30th December 2025

Re: Section 5 Determination under the provisions of Section 5(3)(a) as to whether works within lands at Bauville and Keelogs, Clonglash, Bunrana are exempt development

Whether the installation of plant/machinery for the segregation of coal on lands at Bauville and Keelogs, Clonglash, Bunrana, Co Donegal constitutes exempted development within the meaning of the Planning and Development Acts (as amended).

Front Elevation Facing South

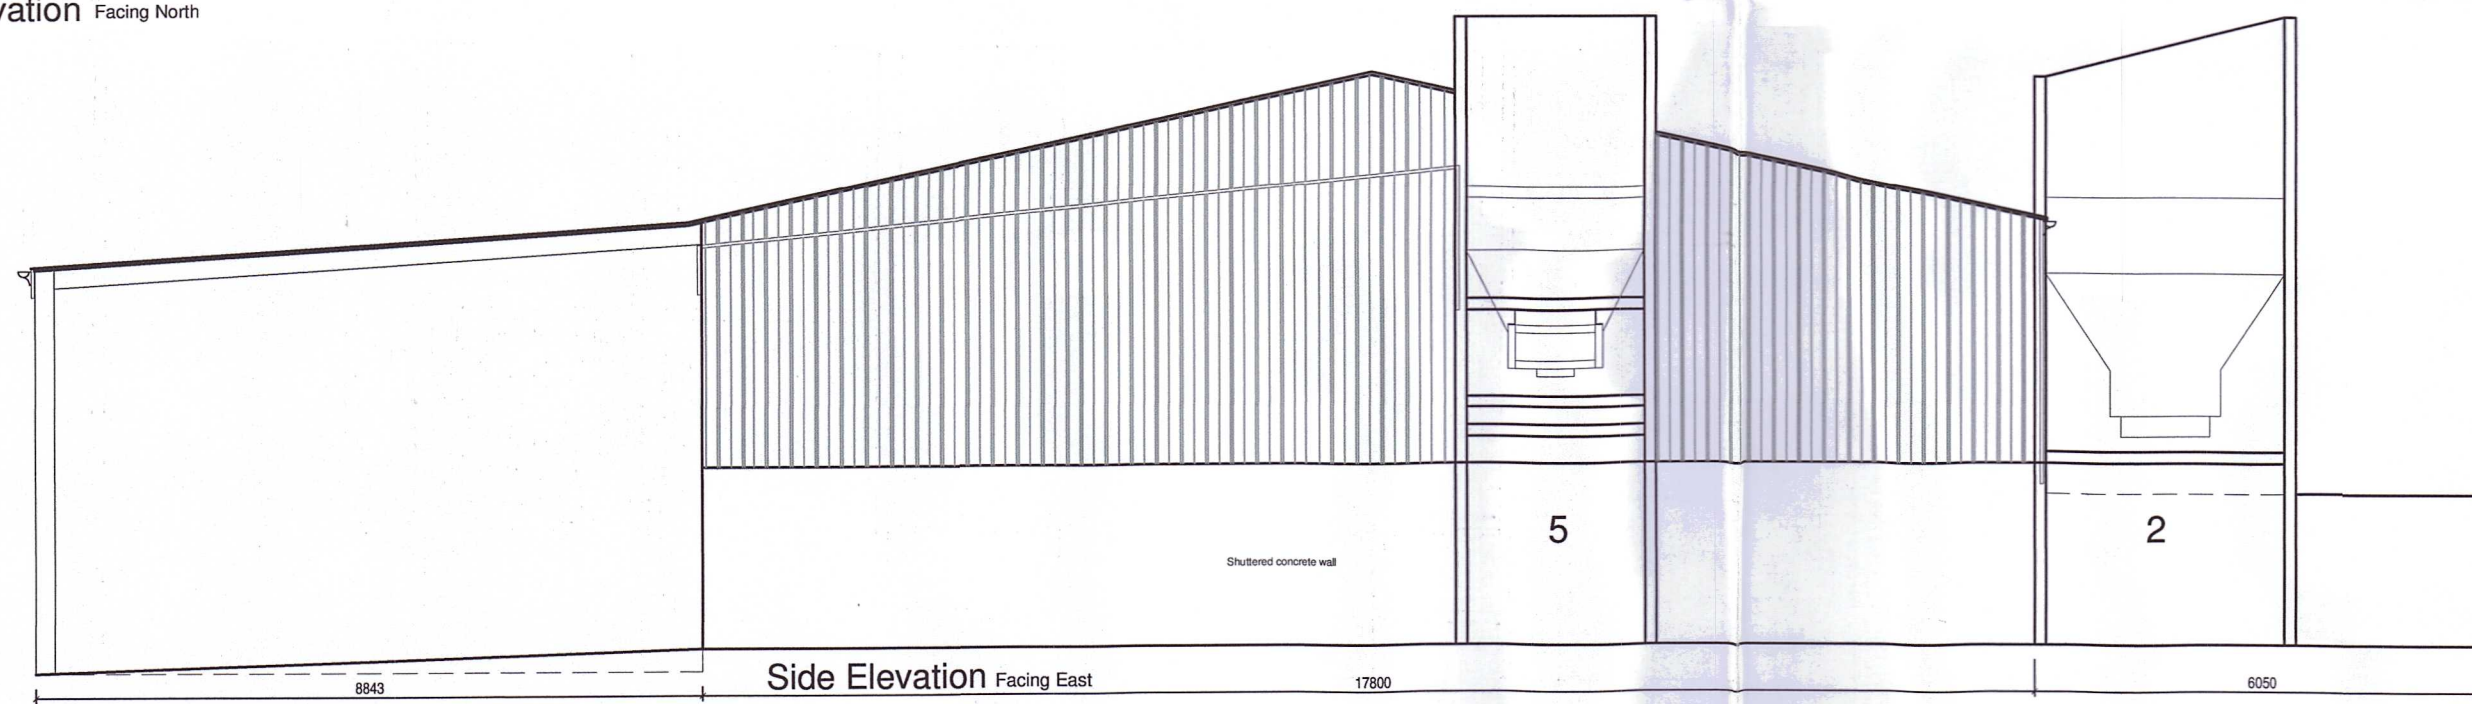
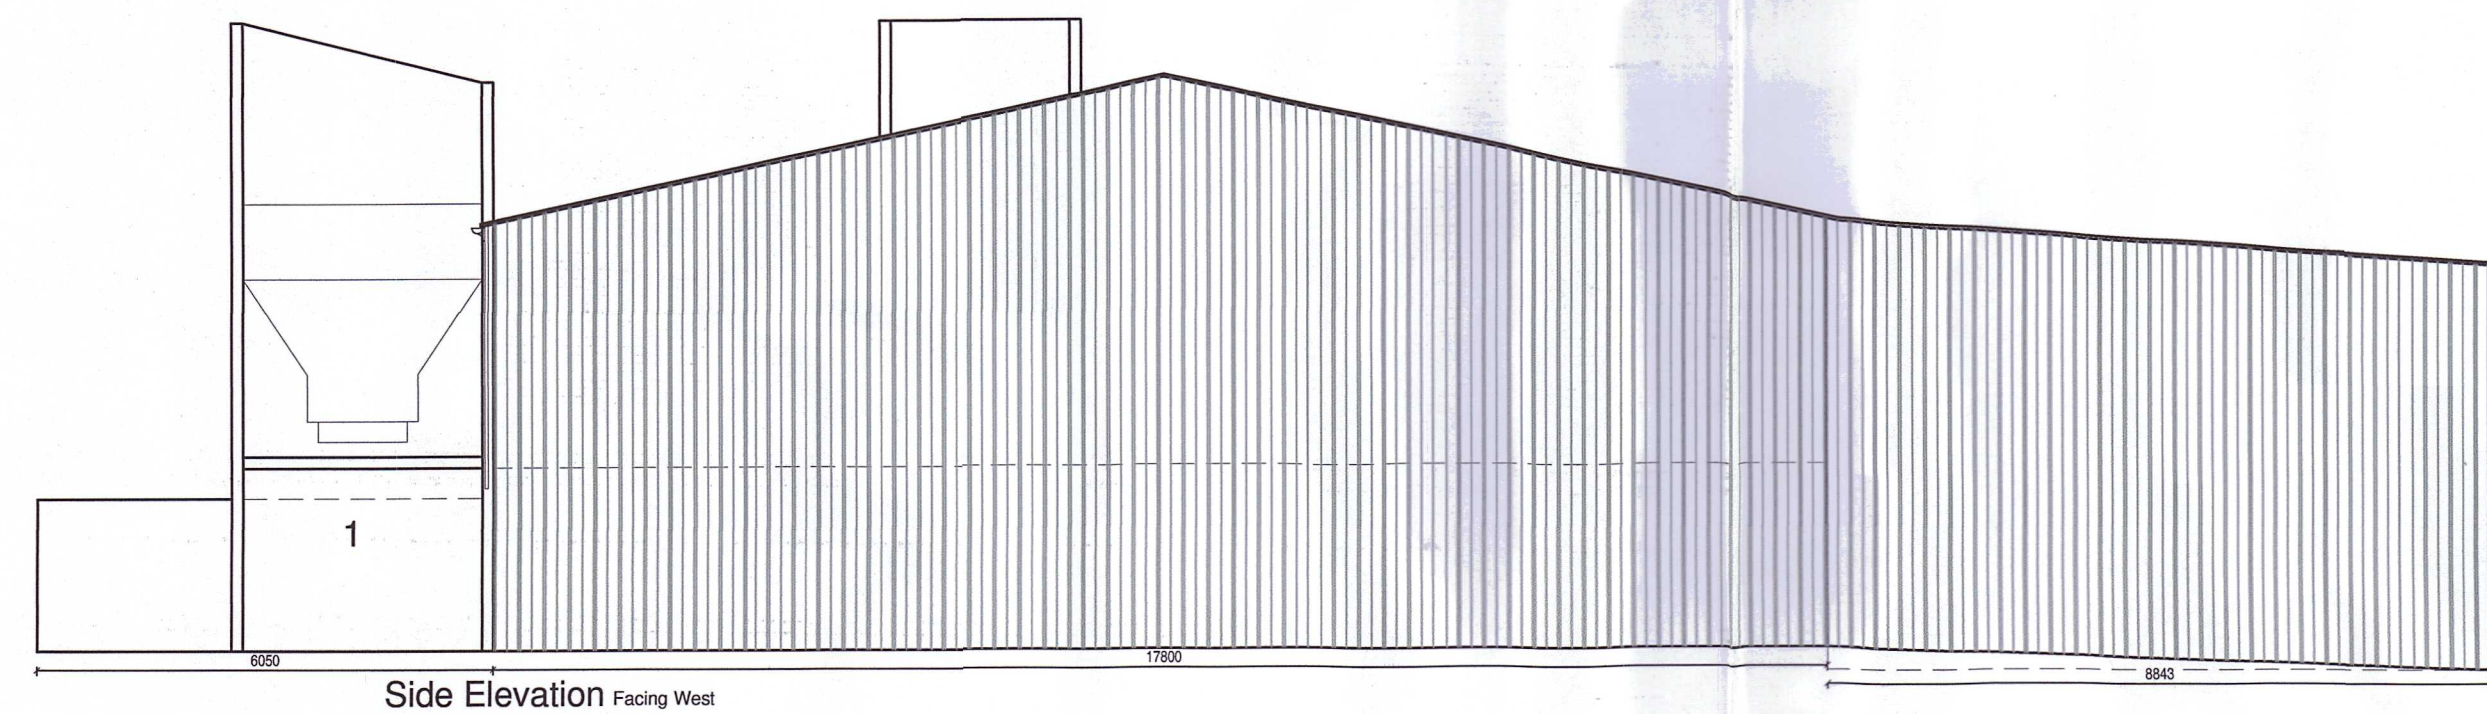
4.5 Indeed with the subject development having a height of 10.75 metres it is clear that condition 8 of ABP's condition is breached.

4.18 With there being no change in site features since application 1950152 was assessed it is clear that the plant and machinery having a height of 10.75 metres would indeed materially alter the external appearance of the premises or the undertaking.
